Our Ref: 22/123110
Our Contact: Lisa Ho – 9562 1663

Re: Bayside Council Submission: Raymond Avenue Multi Level Warehouse Matraville (SSD-31552370)

Thank you for the opportunity to comment on State Significant Development (SSD) application for a warehouse and distribution facility at 42-52 Raymond Avenue and 44A McCauley Street, Matraville in Randwick Local Government Area (LGA).

TITLE: SITE ANALYSIS PLAN & SUMMARY

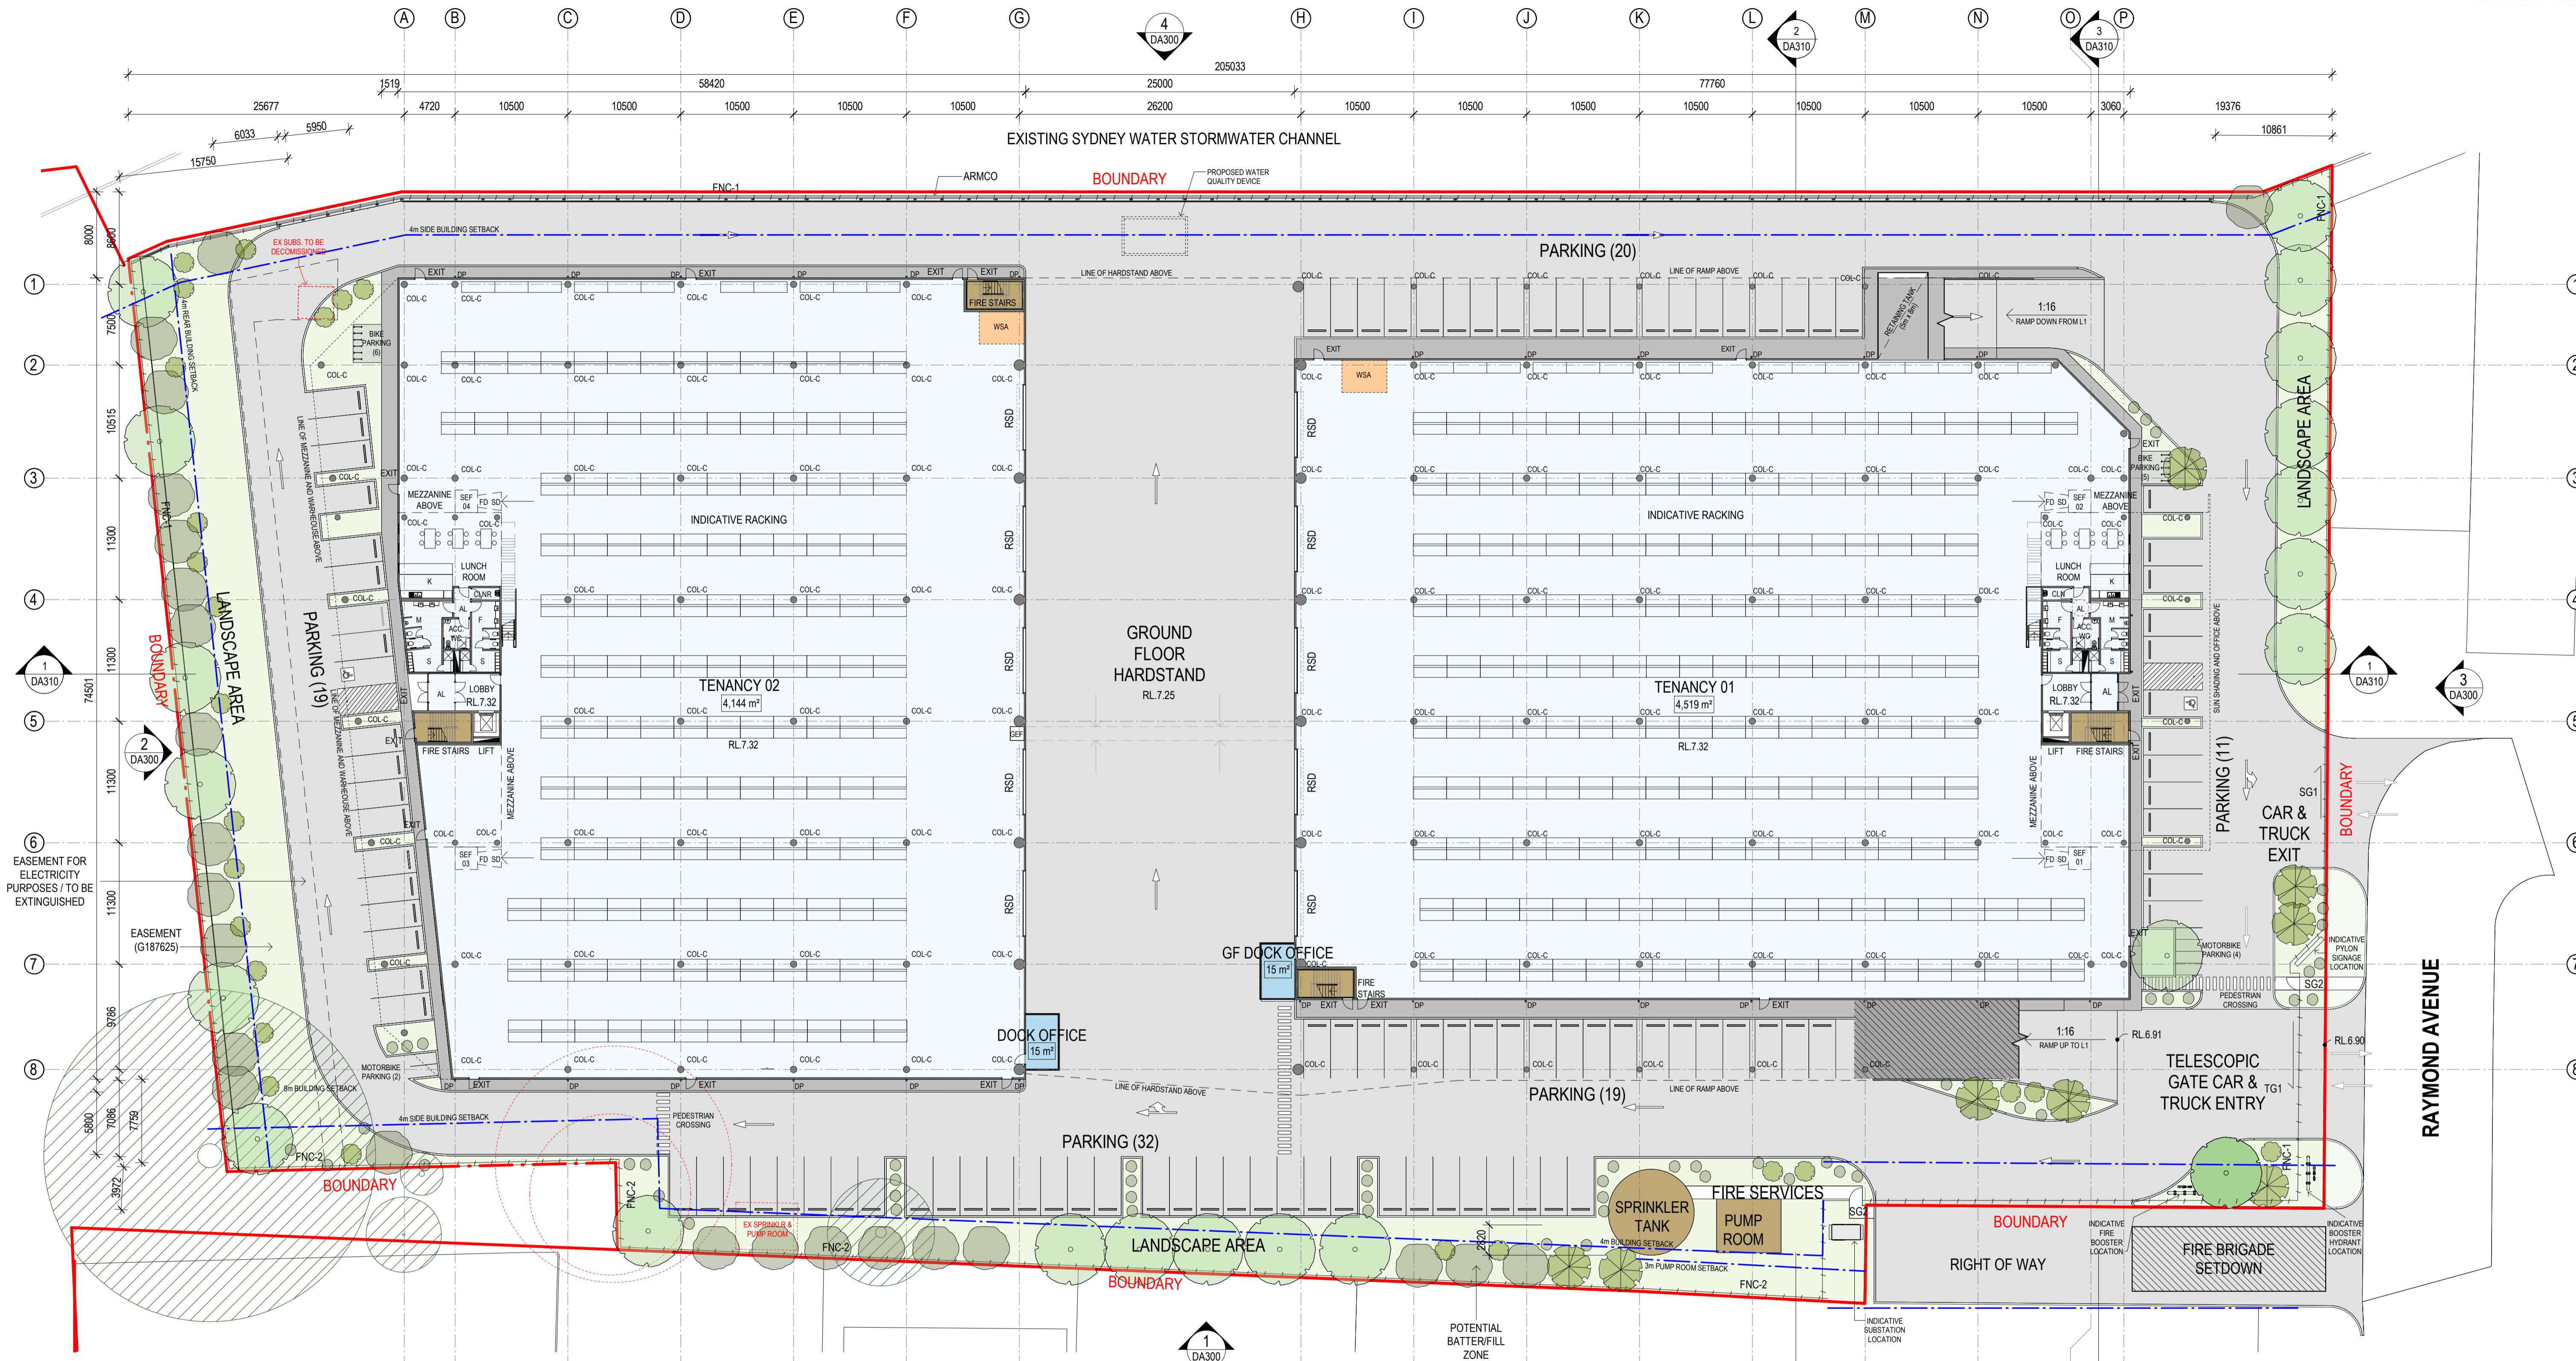
Part of the north western boundary of the site adjoins land within Bayside LGA and they typically comprise of smaller scale industrial development. The proposed development involves a significant building envelope (22m) and building footprint (over 19 000m²). As a result of the scale of this development, when viewed from the north western boundary, the proposed development is likely to present as a large monolithic built area with ineffective landscaping to reduce the apparent extensive bulk and scale in the development, particularly along the north western boundary of the site.

The proposed landscape plan does not include any landscaping along this boundary. Council recommends the inclusion of larger landscaped areas and setbacks along the north western boundary of the site to provide visual breaks and screening to buildings located within the development. In addition, non-reflective materials and colours will need to be included in the finishes for the development to reduce the potential for reflectivity and glare towards neighbouring industrial properties in Bayside as well as reducing visual impacts.

1 SIGNAGE PERSPECTIVE

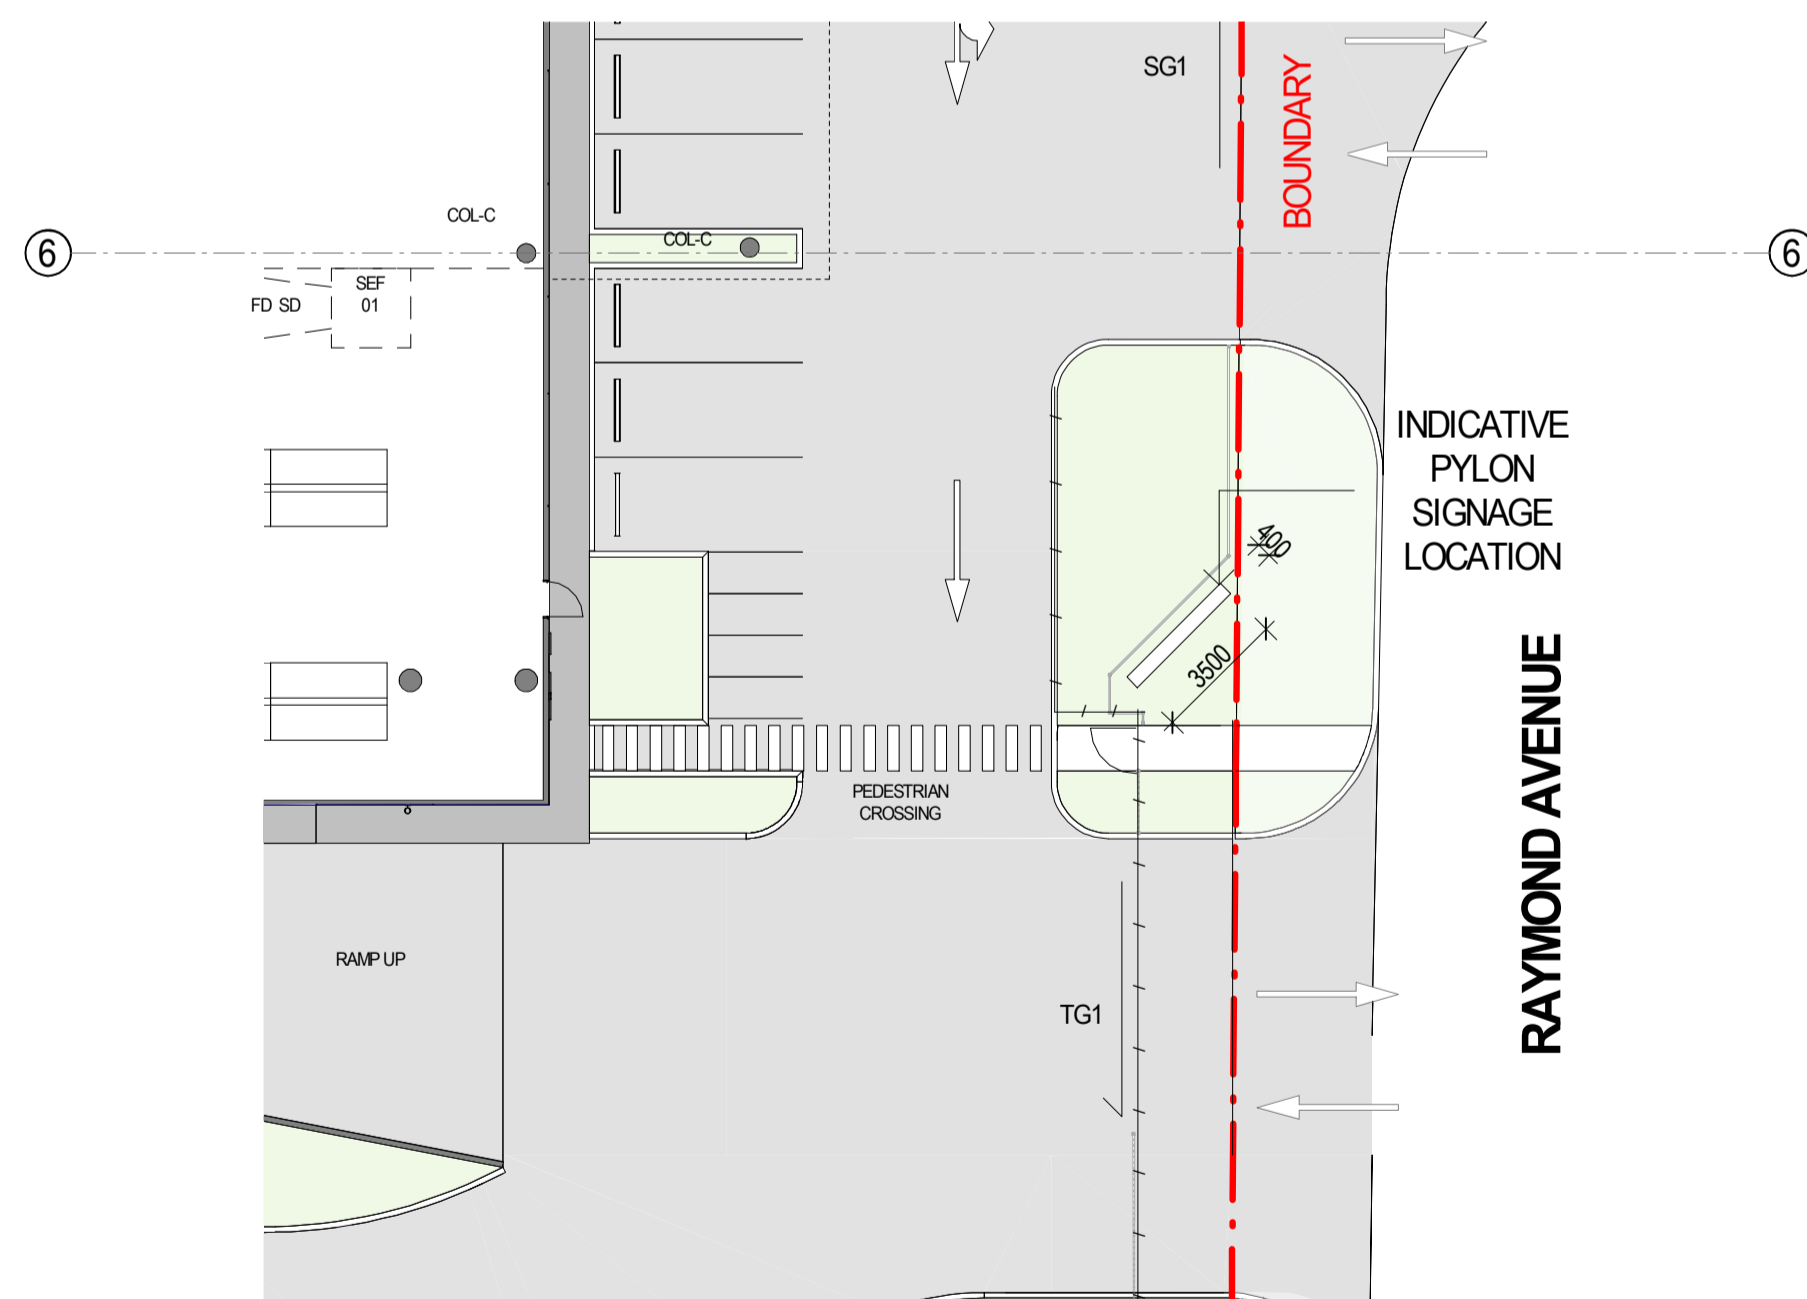
Council officers wish to express concern at the proposed signage and building illumination and the potential for adverse impacts on the amenity of nearby current and future residents. Illumination should be curtailed in terms of hour of illumination and/or illuminated display area.

Appendix A
DRG C014452.00-DA30 “Bulk Earthworks Plan” by
Costin Roe Consulting

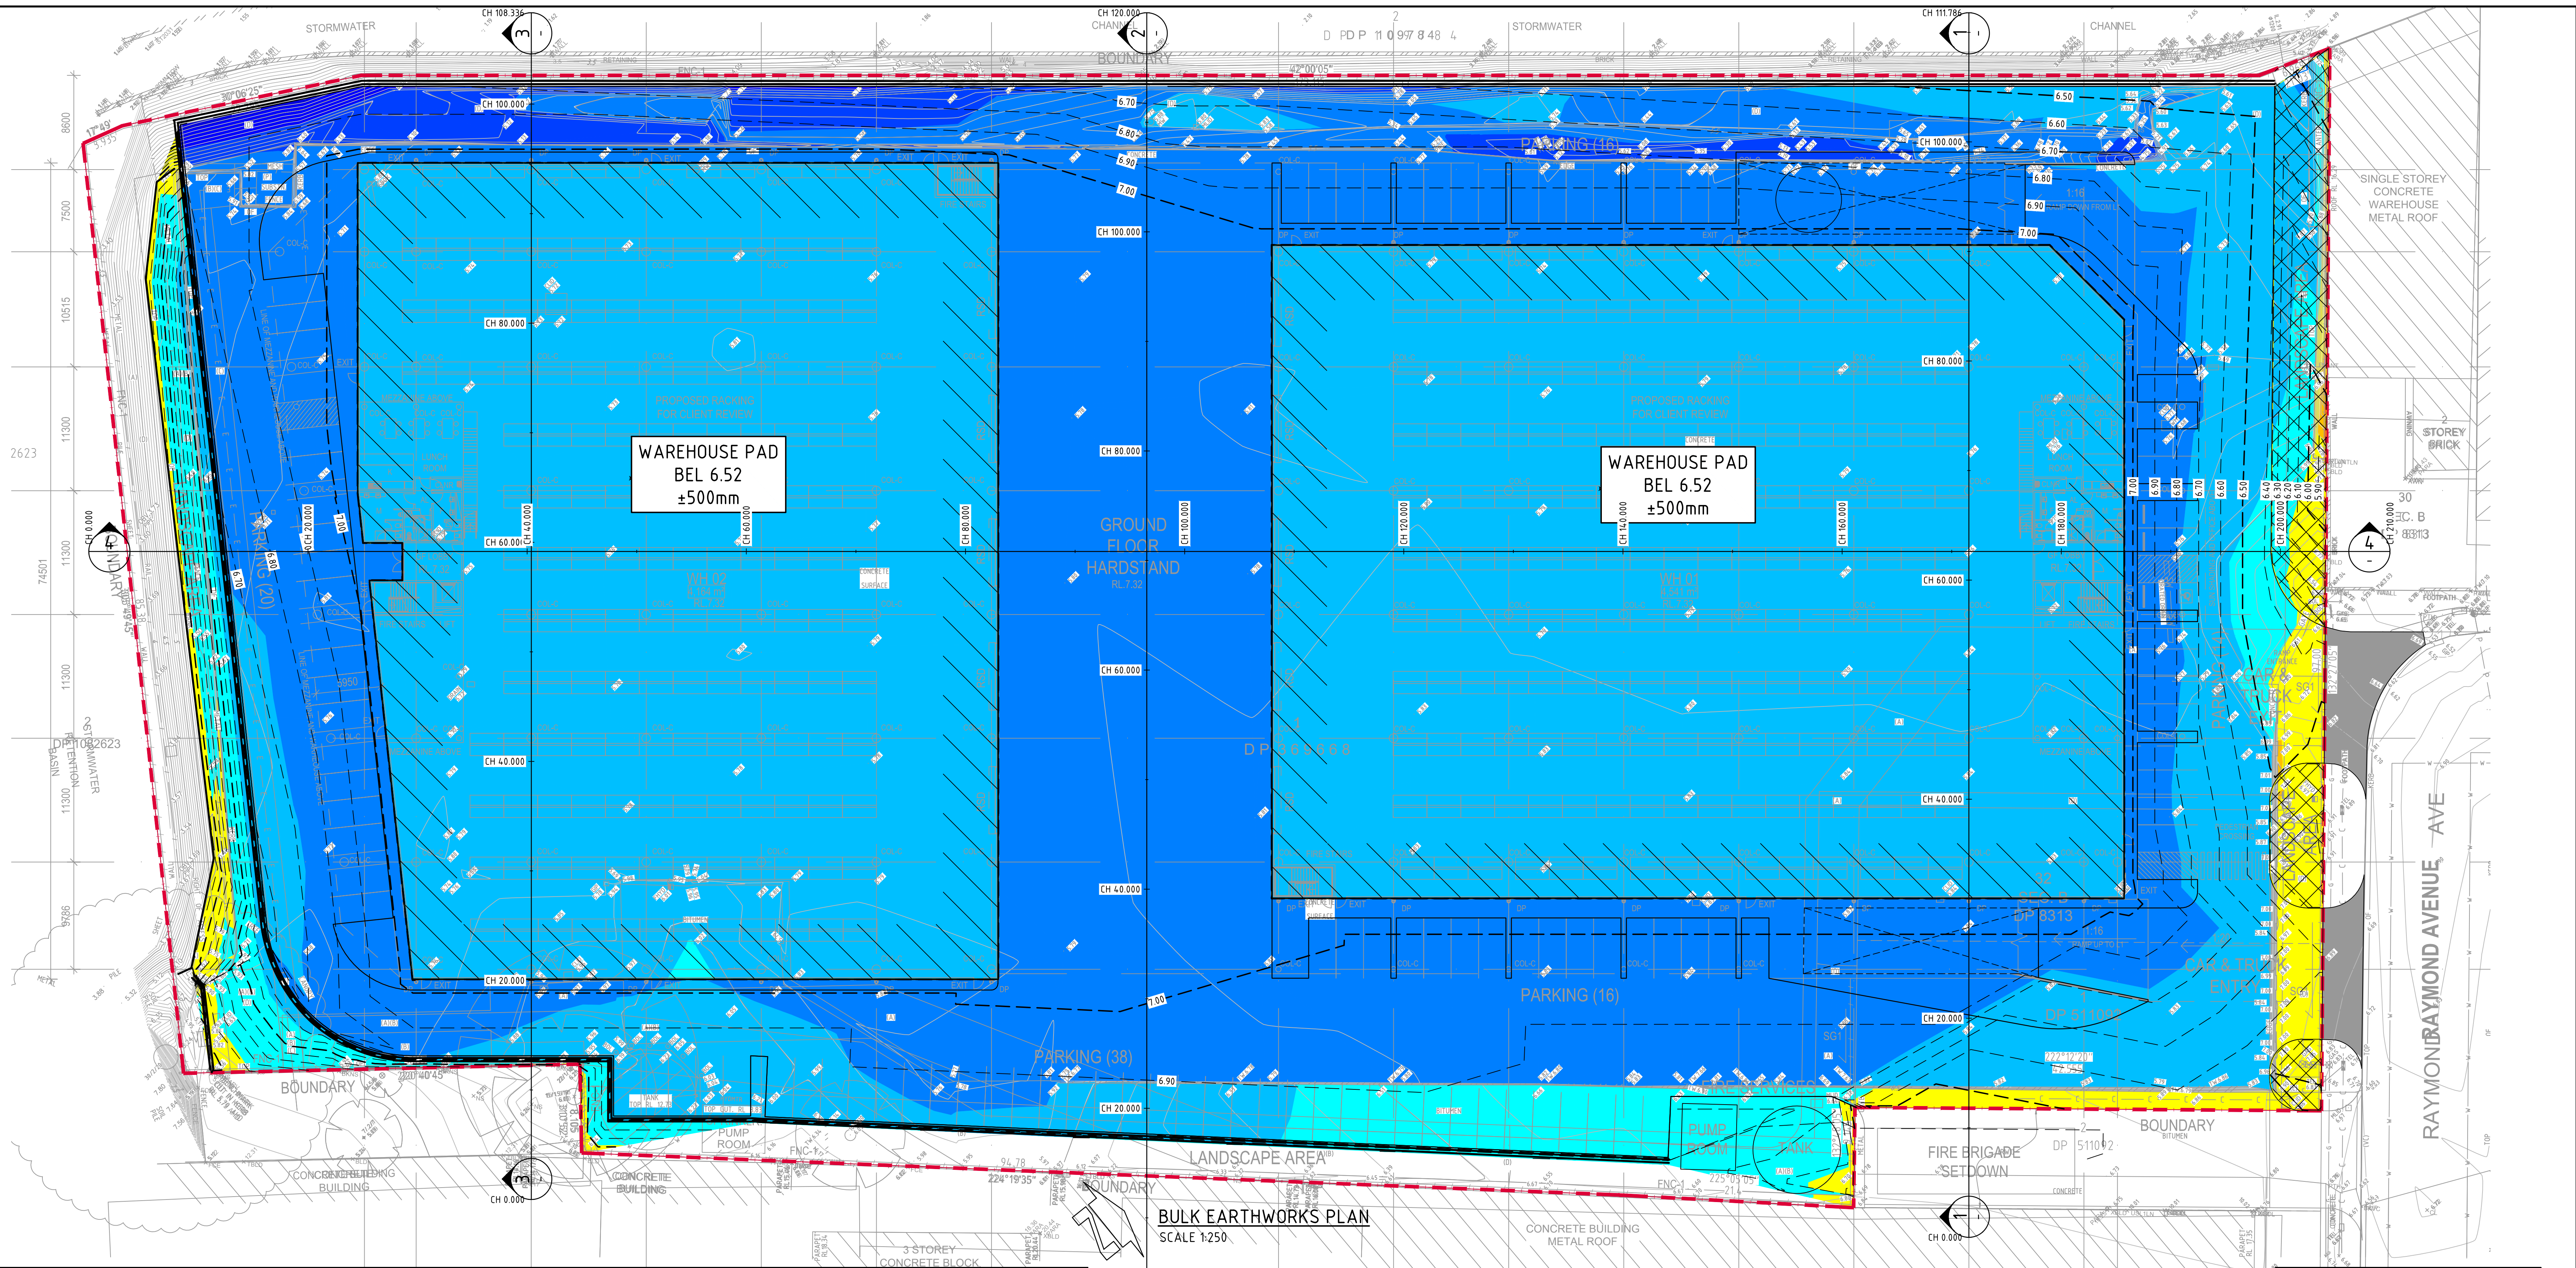
As per the Birds Gully Flood study (Randwick Council 2018), this site is affected by overland flow flooding in the 1% and PMF events. The open channel is considered a floodway in major storm events. The proposed filling of 1.5m above the existing slab level, may redirect flow to the adjoining sites in a major storm event. It is critical to undertake a Flood Impact Study (based on the survey of the site and any new development adjacent to this site) to ensure the proposed development does not adversely affect any adjacent properties. The flood impact assessment shall be undertaken for all flood events up to the PMF event.
